Re. Mount Pleasant Optimisation Project (SSD-10418)

I refer to your request of 2 February 2021 for advice regarding the Mount Pleasant Optimisation Project Environmental Impact Statement (EIS). The Resources Regulator has reviewed the request.

MACHEnergy MOUNT PLEASANT OPTIMISATION PROJECT Conceptual Final Landform

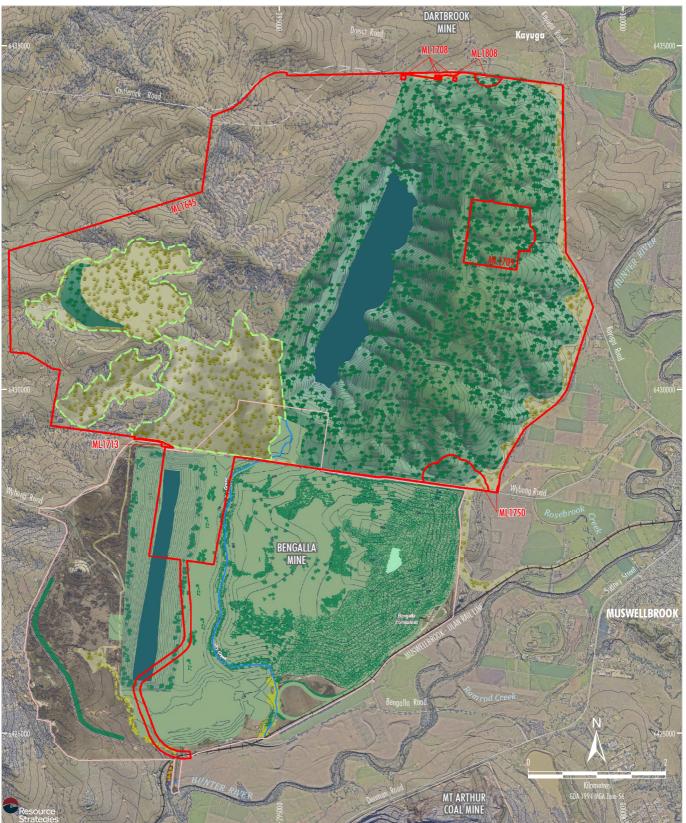
5	Further definition of rehabilitation objectives, in particular the type of vegetation or target vegetation communities in the rehabilitated areas.
6	Further information is required on the conceptual final landform to show all final landform surface water management structures (including spillways) associated with the fines emplacement facility.
